MEMORANDUM TO: Division Environmental and Construction Units

SUBJECT: Environmental Permits for the Improvements to NC 150 in Catawba and Iredell Counties Division 12, **TIP: R-2307.**

Permit Site Changes between 2020 and 2024 Permitting:

PERMIT DRAWING  
SHEET 6 OF 22

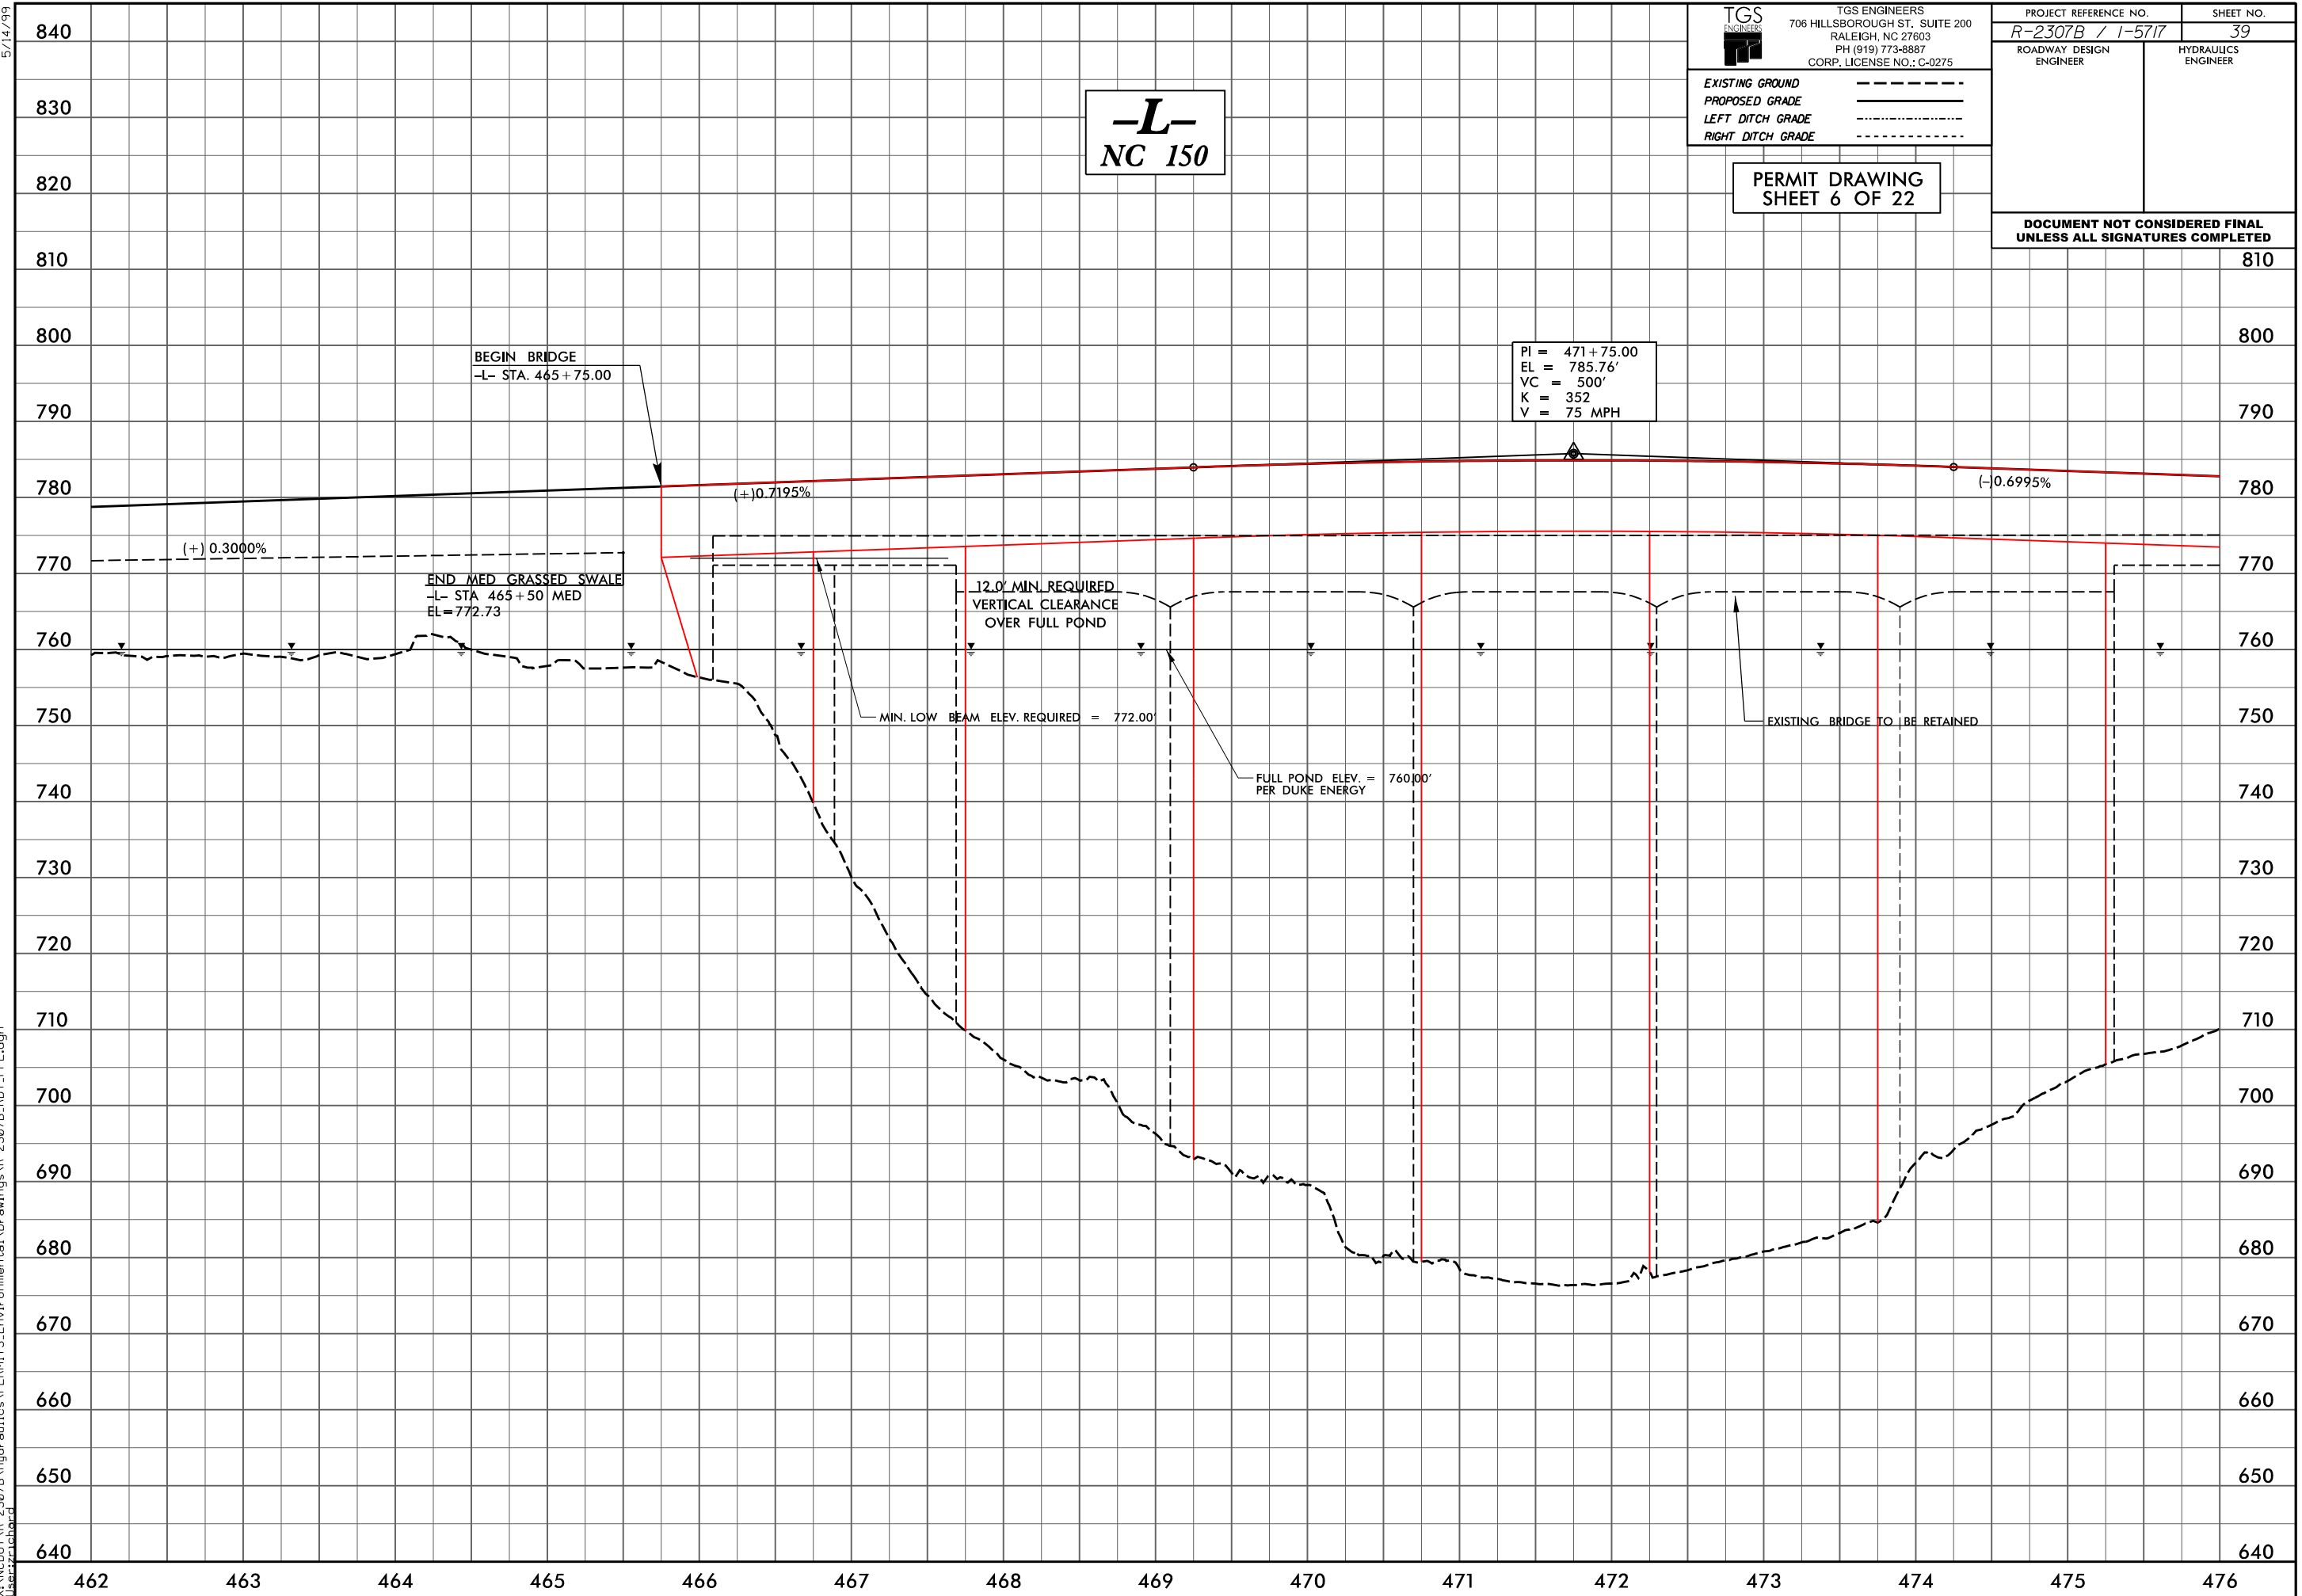
Site 3/ Permit Drawing Sheets 4-6: Due to concerns from Duke Energy regarding boater safety and the alignment of bridge piers with the existing structure, the proposed bridge span arrangement was modified to better match the existing bridge. Permit Drawing Sheets 4-6 and associated footnote on the Impact Summary Sheet were updated.

PERMIT DRAWING  
SHEET 7 OF 22

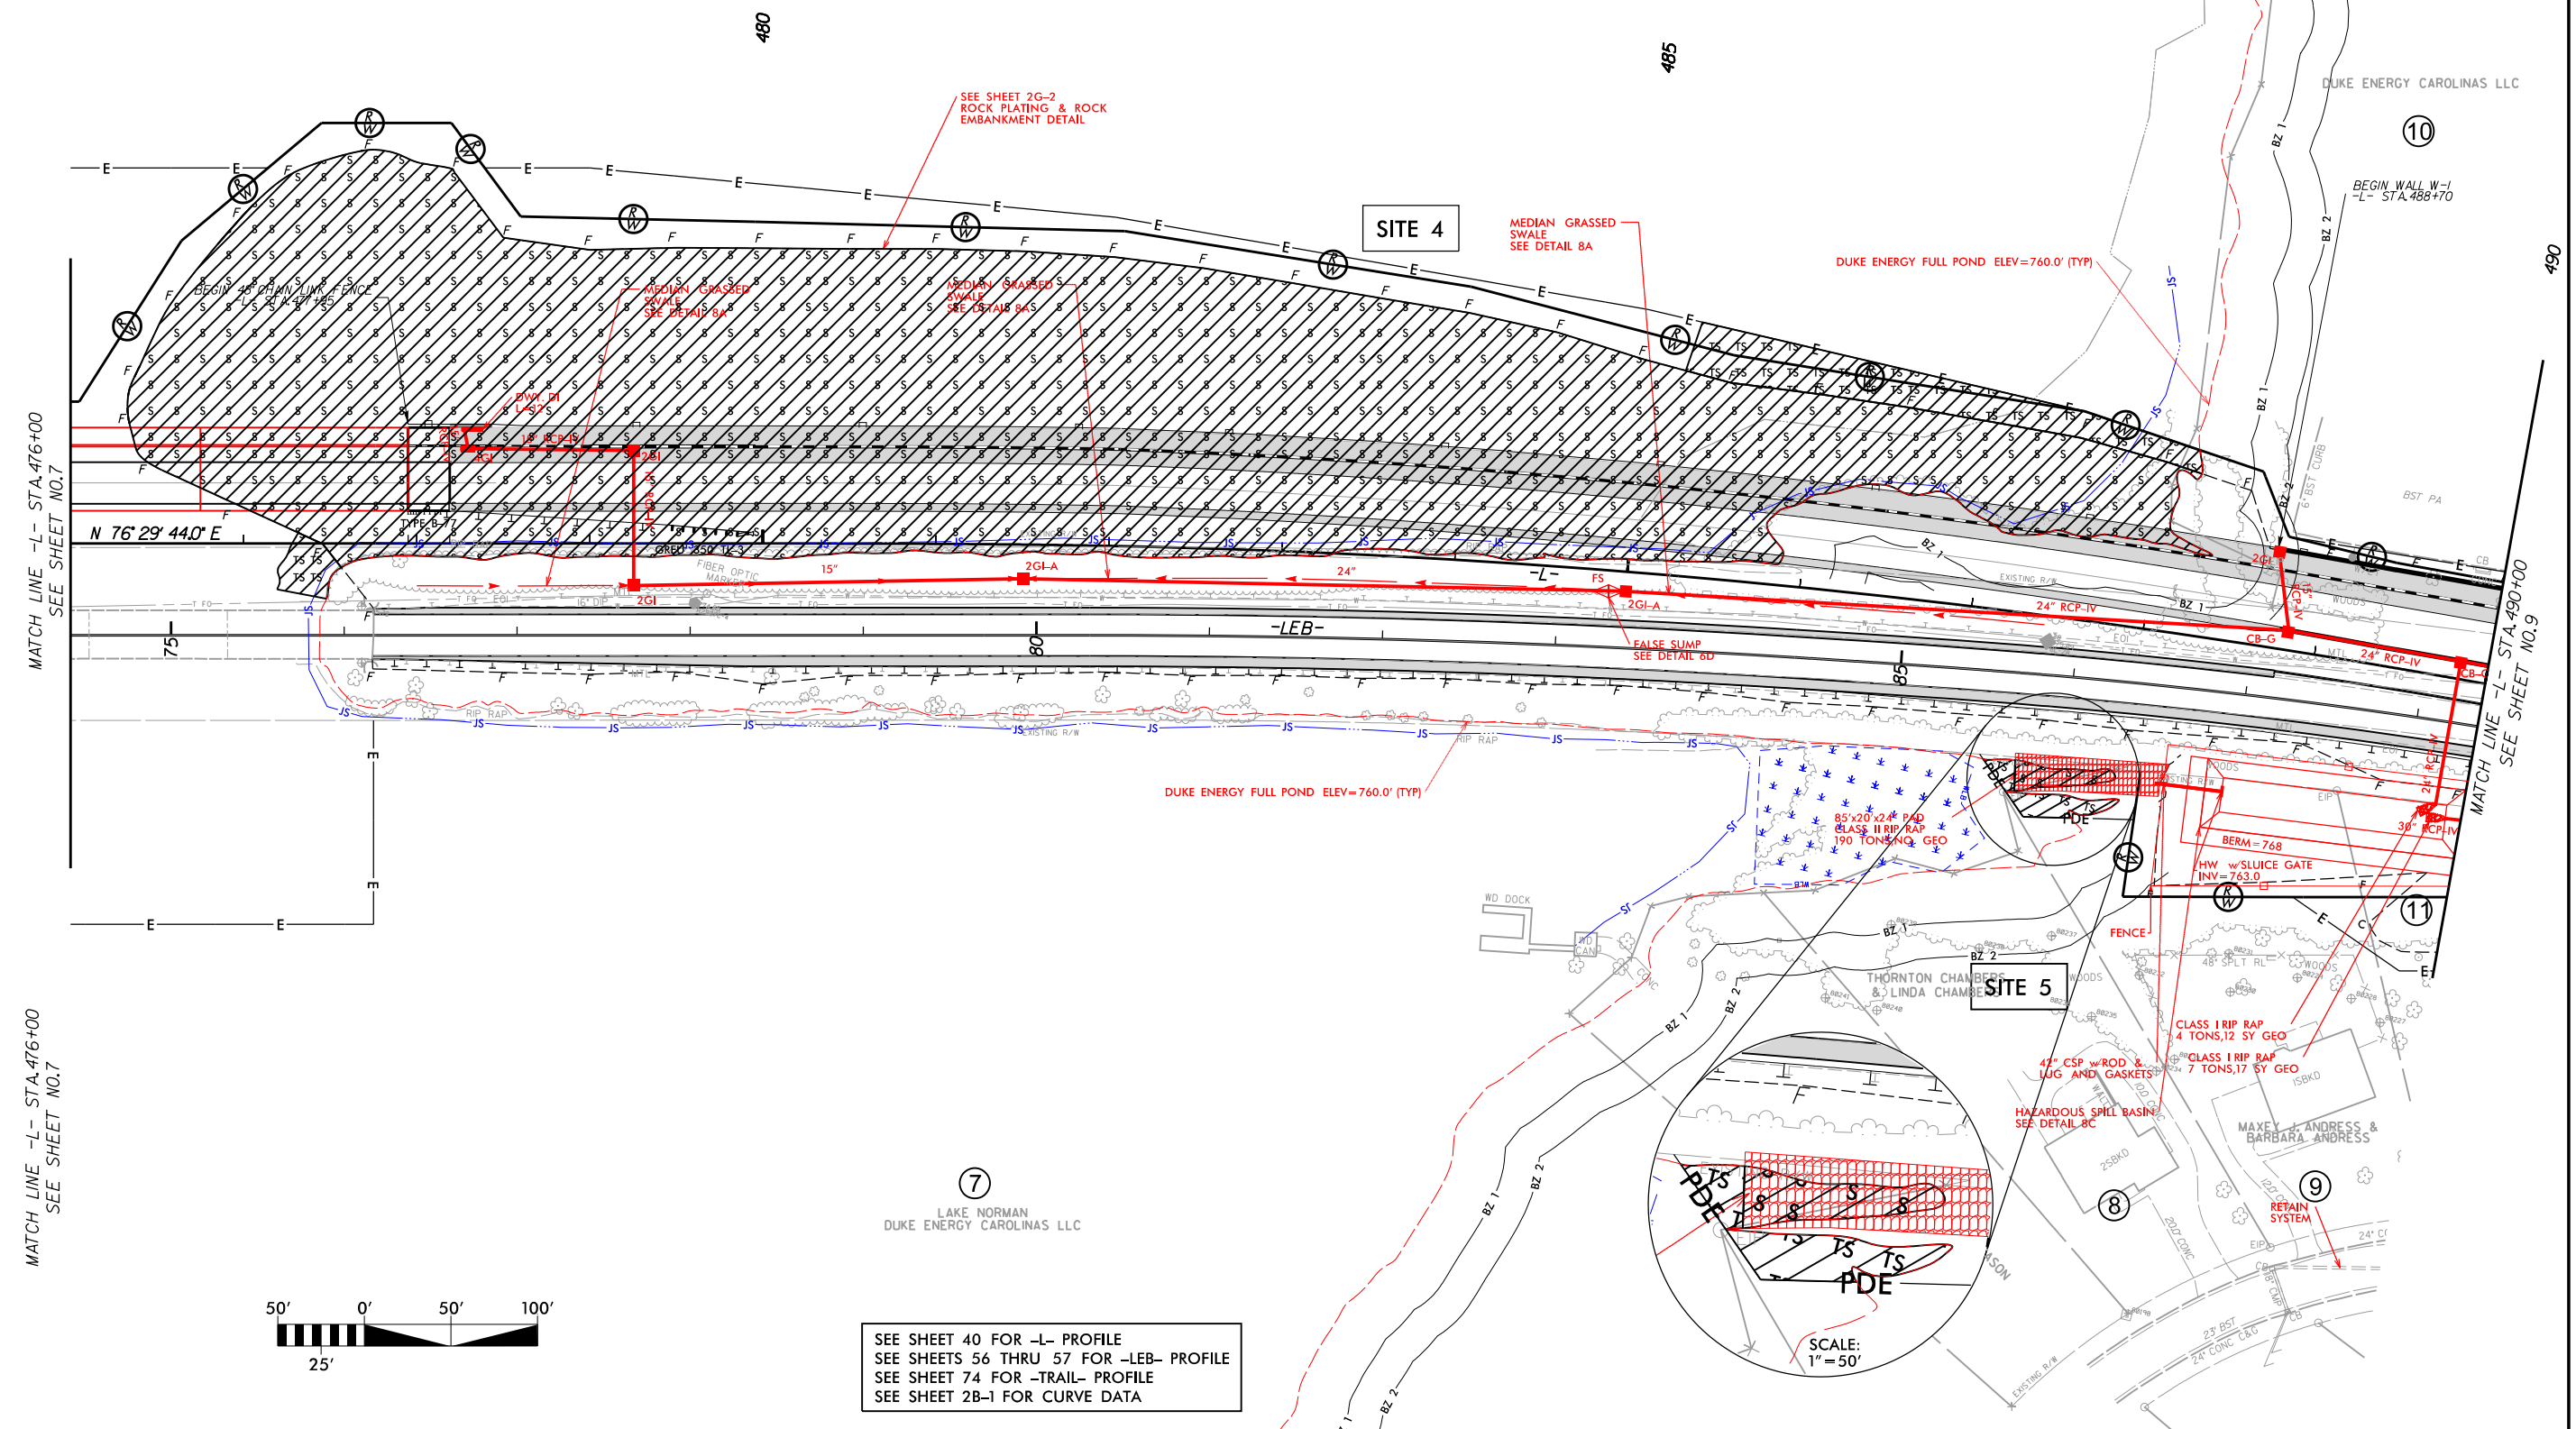
Site 4: Two temporary Surface Water Impacts were added down to elevation 750 ft on Permit Drawing Sheets 7-8. Temporary Surface Water Impacts increased from 0 to 0.162 acre.

SITE 10

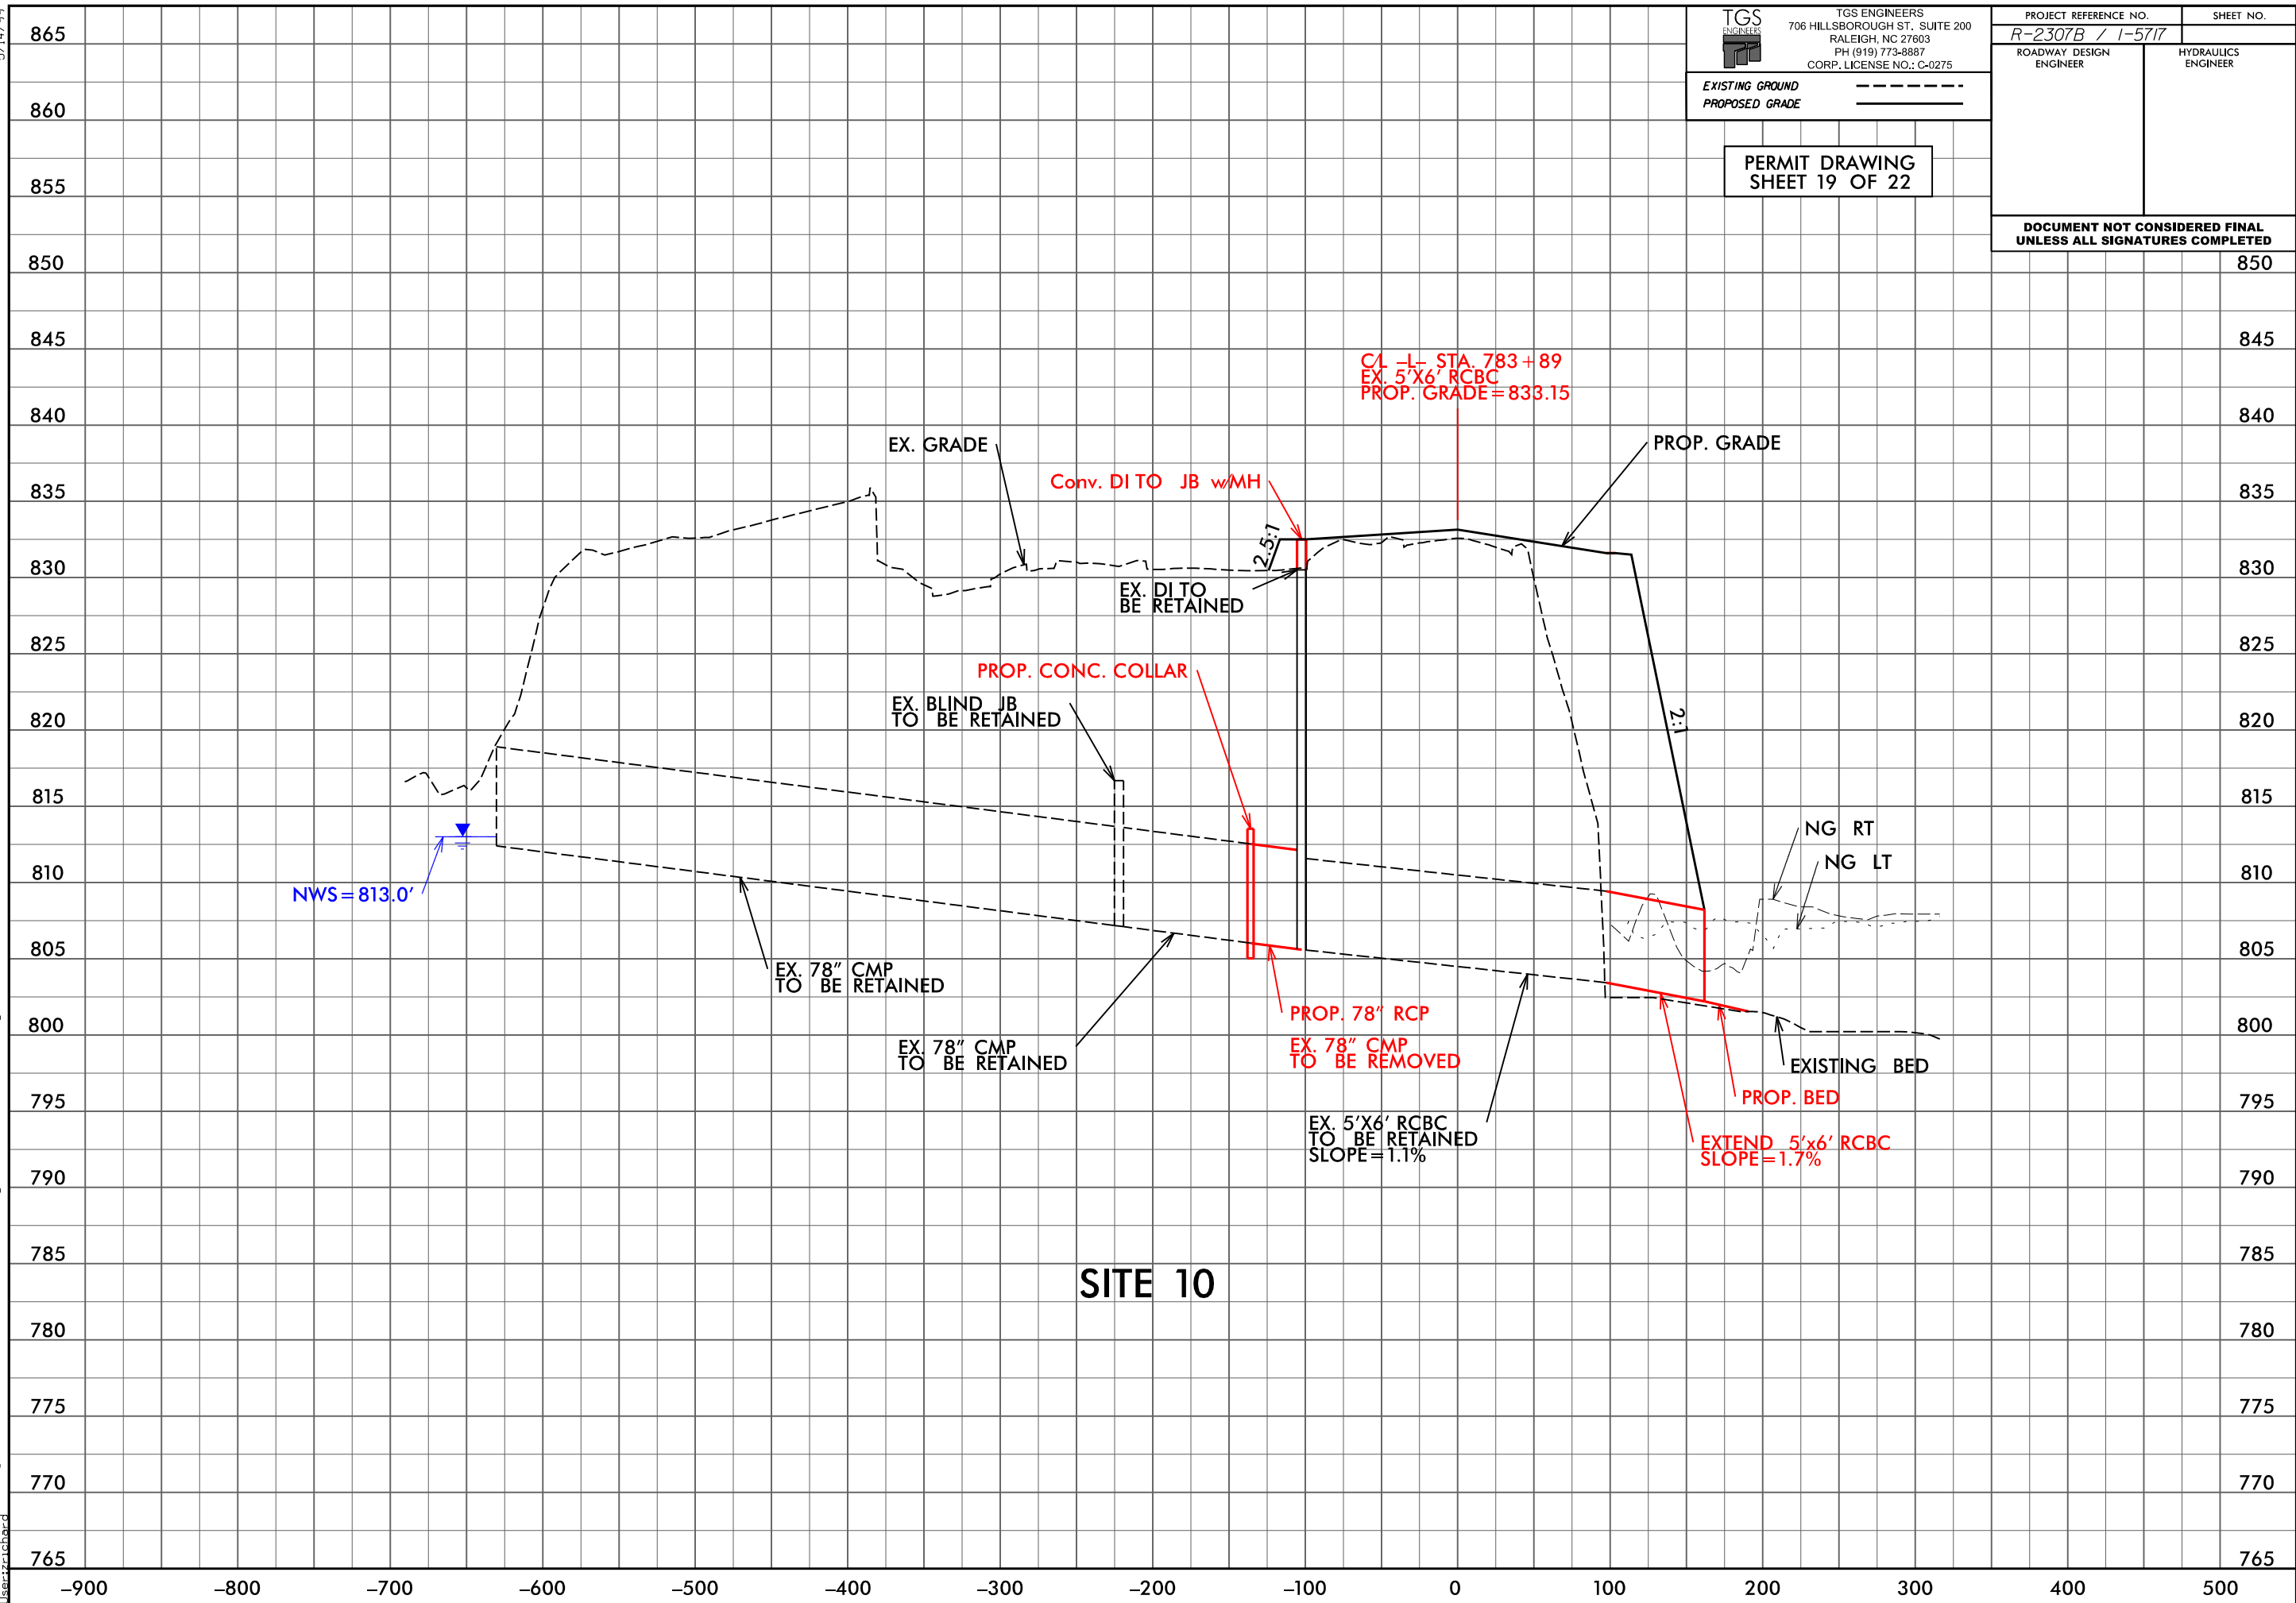
Site 10: The previous design proposed a 9' diameter precast manhole connecting an existing RCBC to a proposed 78" RCP at the downstream culvert extension at 784+50 RT (Permit Site 10). NCDOT determined that attaching a precast manhole to the existing RCBC is not feasible and would require a cast in place connection. To avoid this situation, the existing 5'W x 6'H RCBC will be extended. This will result in the outlet of the RCBC shifting 3' west of the previous 78" RCP outlet. However, the inverts, lengths, and channel layout will remain the same. There are no changes to stream impacts.
